Post Hearing Note following the Open Floor hearing 5th March 2019

Deadline 7 submission

Dafydd Griffiths on behalf of the NACP

Post Hearing Response – Deadline 7
Route of the Lôn Las Copr / Copper Trail
Dafydd Griffiths on behalf of the NACP

Figure 1-6 A5025 Off-line Highway Improvements Power Station Access Road Junction

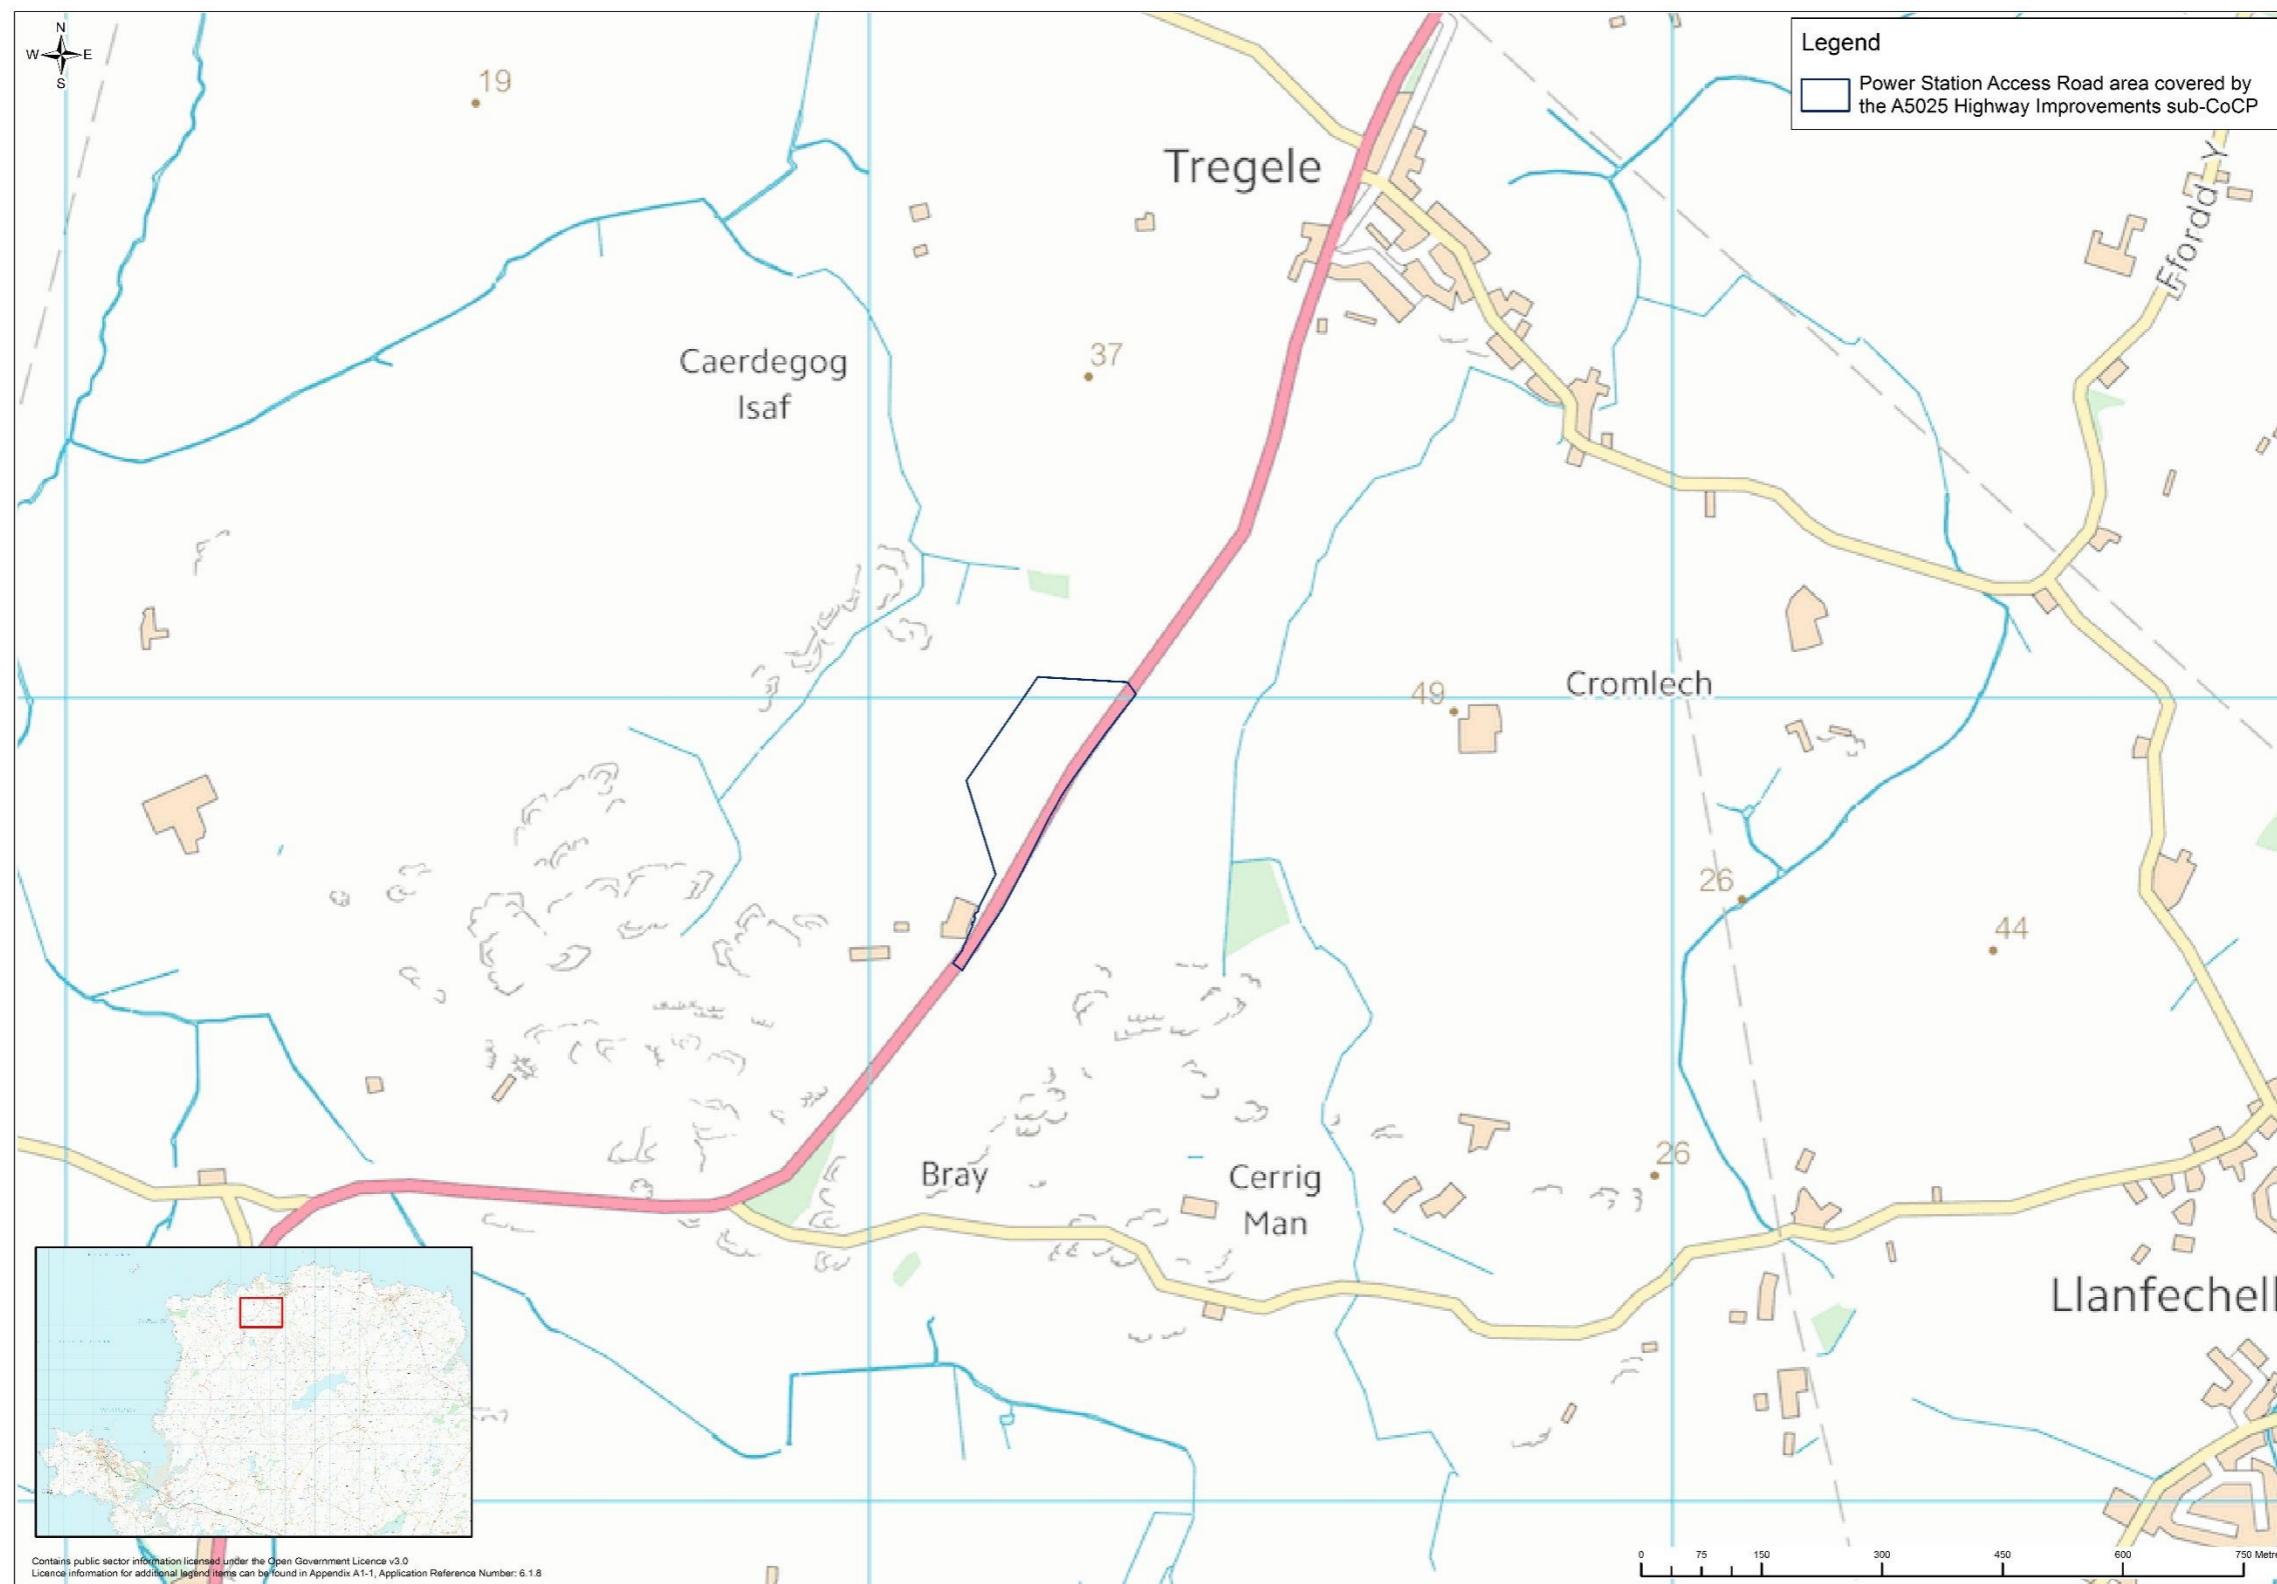
Concerns have been raised during the pre-application process and during the examination at deadline 2, deadline 4 and deadline 6 that improvements proposed on the A5025 between Valley, the WNDA and Cemaes have not given sufficient weight to the impact on Non-motorised Users (NMU).

At deadline 4 the NACP identified specific sections of the A5025 where the applicant was proposing NMU infrastructure but in the opinion of the NACP the proposals were inadequate. The NACP also identified other specific sections of the A5025 where the applicant currently had no NMU infrastructure proposals but where, in NACP's view, mitigation was needed. At deadline 6, as a follow up to the Accompanied Site Inspection that took place on the 14th February 2019, the NACP submitted further comments and proposals on the most appropriate route for the Lôn Las Copr / Copper Trail during both the construction and operational phases of the Wylfa Newydd Power Station.

The NACP are of the view that the Lôn Las Copr / Copper Trail could and should be routed as close to its original route as is possible and desirable during both the construction and operational phases of the Wylfa Newydd project.
